Transport
for NSW

**State Significant Development
Wallahah 2 Coal Project (SSD 4974)
Exhibition of Environmental Impact Statement**

**TRANSPORT FOR NSW TRANSPORT CLUSTER COMMENTS
EXHIBITION OF ENVIRONMENTAL IMPACT STATEMENT
WALLARAH 2 COAL PROJECT (SSD 4974)**

Figure 3: Conceptual Project layout: Tooheys Road Site.

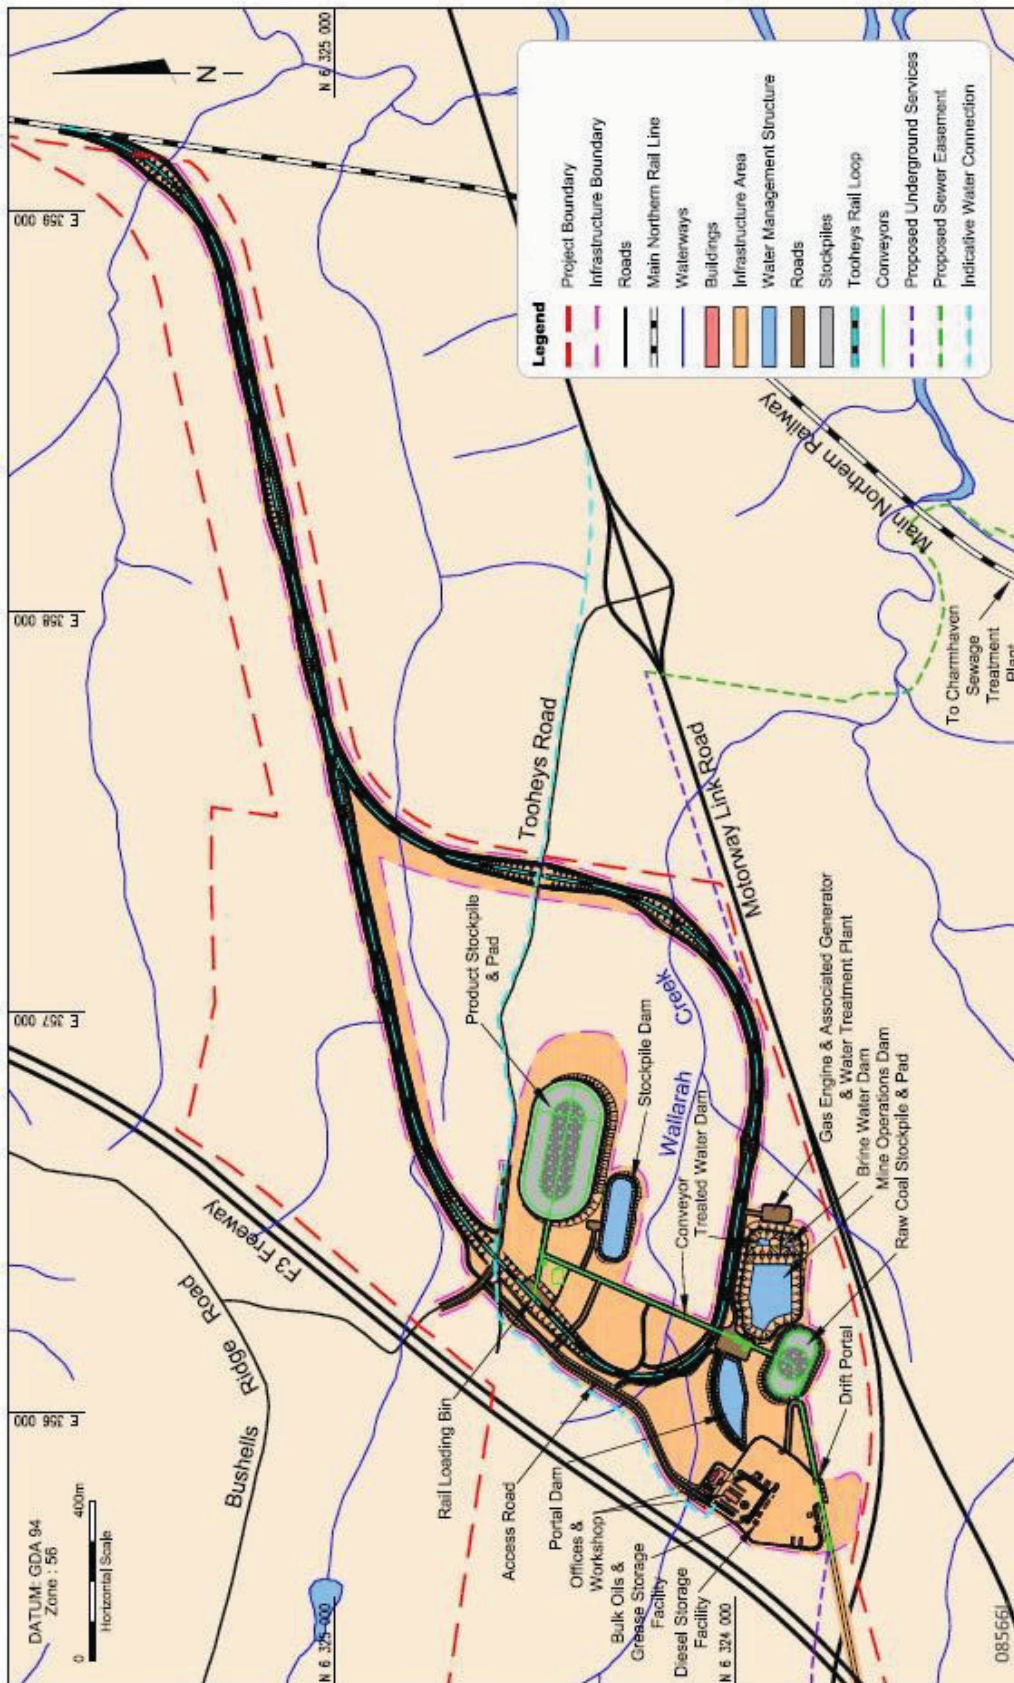
- The Tooheys Road site access is located immediately to the west of one of the balloon loop bridges. In the absence of any further detail regarding the geometry of this intersection it appears that a potential safety issue is Safe Intersection Sight Distances given that the proximity of the bridge and abutments could impede sight distance. What vertical clearance is proposed? Will any high vehicle access be required during operation? It is not clear if the F3 underpass is sufficient in this regard. Detail design should address all these issues to the satisfaction of RMS.

**Figure 2 - Mine layout**

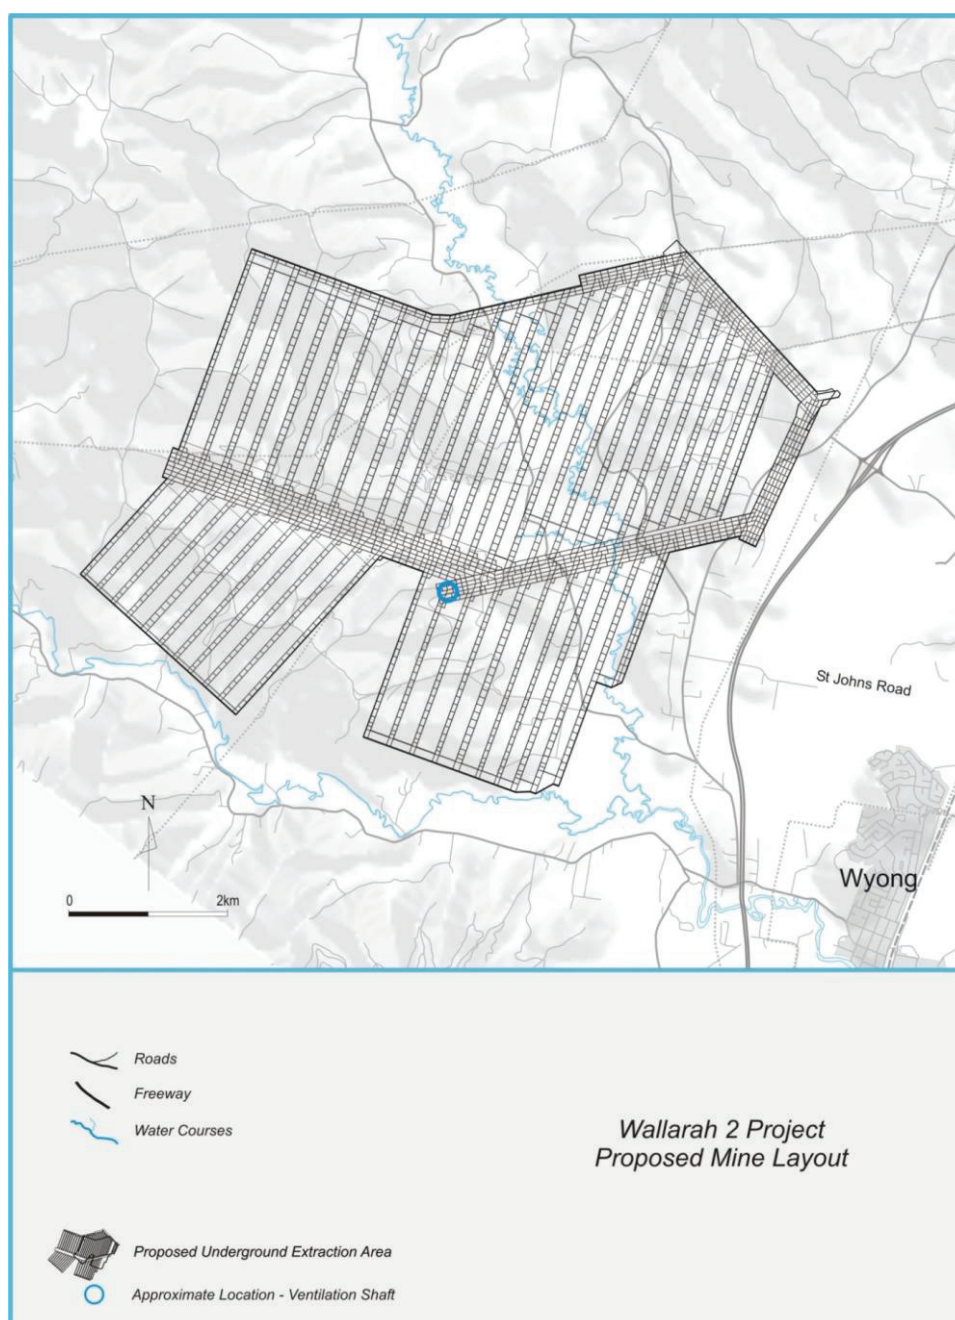
- Coal Handling / Loading. Only a general arrangement of the rail loop and coal handling infrastructure is shown. Director General Requirements require detailed description and plans of any proposed building works.
- It is unclear from the Rail System Capacity Assessment discussion what the demand year is. The RailSys graphs have Wallarah 2 paths superimposed on North Sydney Freight Corridor Stage 1 paths, so presumably this is out to 2028. Mine life is expected to be until 2041. The proponent should clarify this.

- Page 4: Mine Operation: “There will be no coal handling and preparation plant....”. This is inconsistent with the project description provided in the Introduction. The Introduction mentions “The mine will produce a single thermal coal product to be marketed for export and domestic electricity generation.” While the domestic scenario is unlikely and excluded from analysis, if it were to eventuate how would coal be transported to either Vales Point or Eraring given that the existing turnouts face the wrong way? Would trains travel the Teralba “detour” through Newcastle, require new south facing turnouts, or does road hauling become an option? Again, while unlikely, the scenario is not discussed in either road or rail appendices. While a full analysis is probably not required a most likely method of transport should be identified.
